8 June 2022

TfNSW Reference: SYD22/00534/01  
DPE Reference: SSD-36156297

**EXHIBITION OF EIS - DHL WAREHOUSE & DISTRIBUTION CENTRE - 813  
WALLGROVE ROAD, EASTERN CREEK**

Figure 1 The Development Site Plan

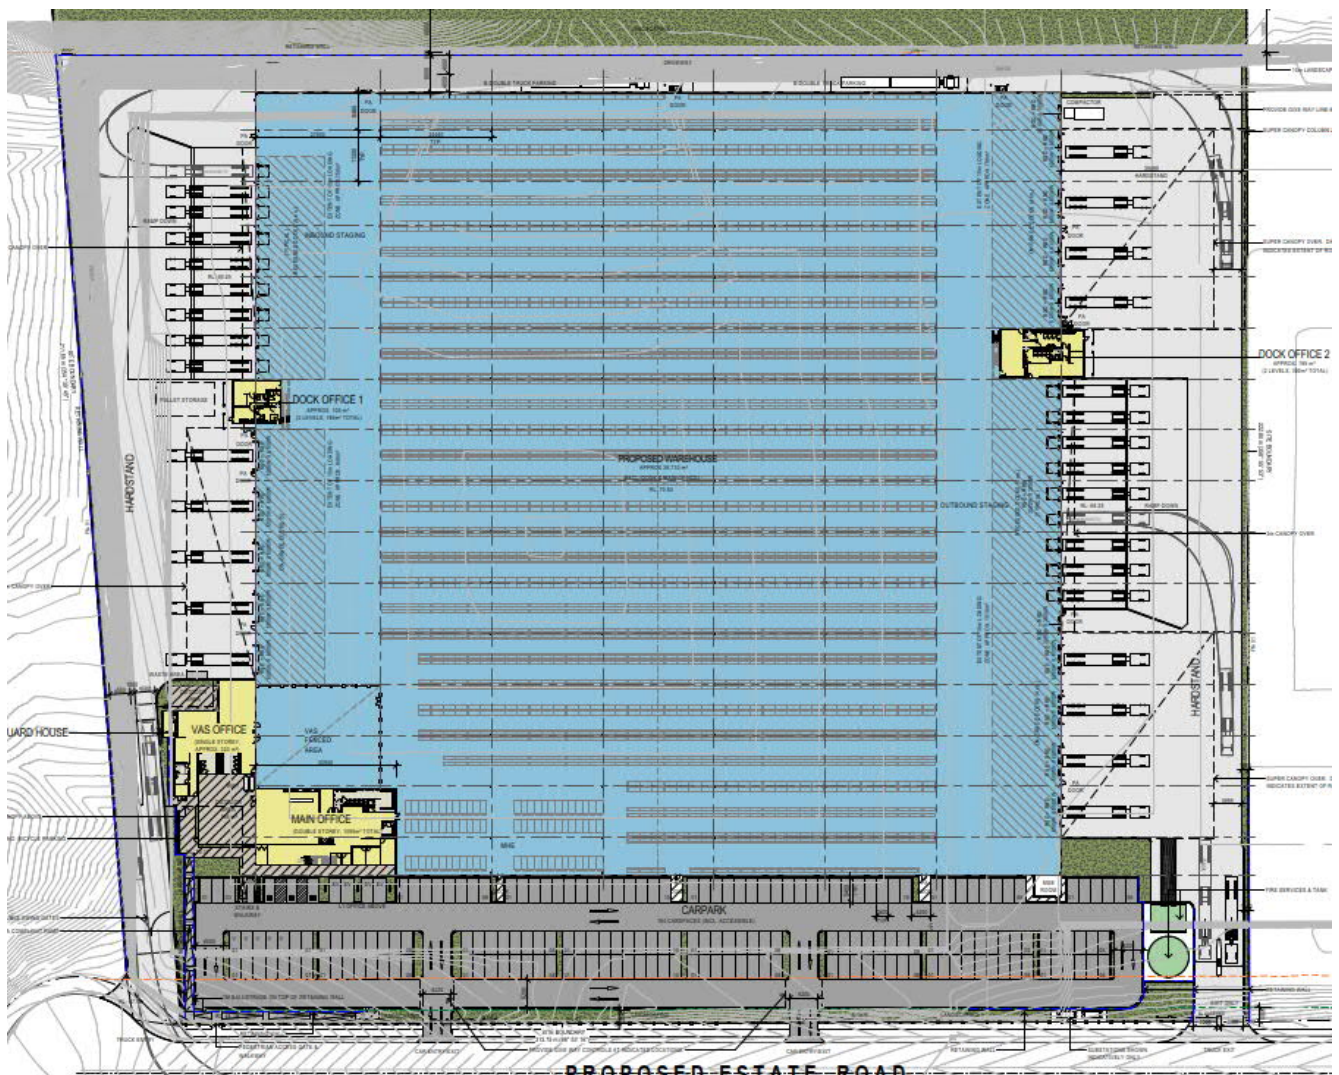
4. The proposed access and manoeuvring arrangements should be in accordance with the following requirements:
  - a. The swept path of the longest vehicle (including garbage trucks, building maintenance vehicles and removalists) entering and exiting the subject site, as well as manoeuvrability through the site, shall be in accordance with AUSTROADS. In this regard, a plan shall be submitted to Council for approval, which shows that the proposed development complies with this requirement.

- b. The layout of the proposed car parking areas associated with the subject development (including, driveways, grades, turn paths, sight distance requirements in relation to landscaping and/or fencing, aisle widths, aisle lengths, and parking bay dimensions) should be in accordance with AS 2890.1-2004, AS2890.6-2009 and AS 2890.2-2018 for heavy vehicle usage. Parking Restrictions may be required to maintain the required sight distances at the driveway.

- c. All vehicles are to enter and leave the site in a forward direction.
  - d. All vehicles are to be wholly contained on site before being required to stop.

- e. The proposed development will generate additional pedestrian movements in the area. Pedestrian safety is to be considered in the vicinity.
5. An Operational Traffic Management Plan (OTMP) is required to be prepared prior to occupancy.
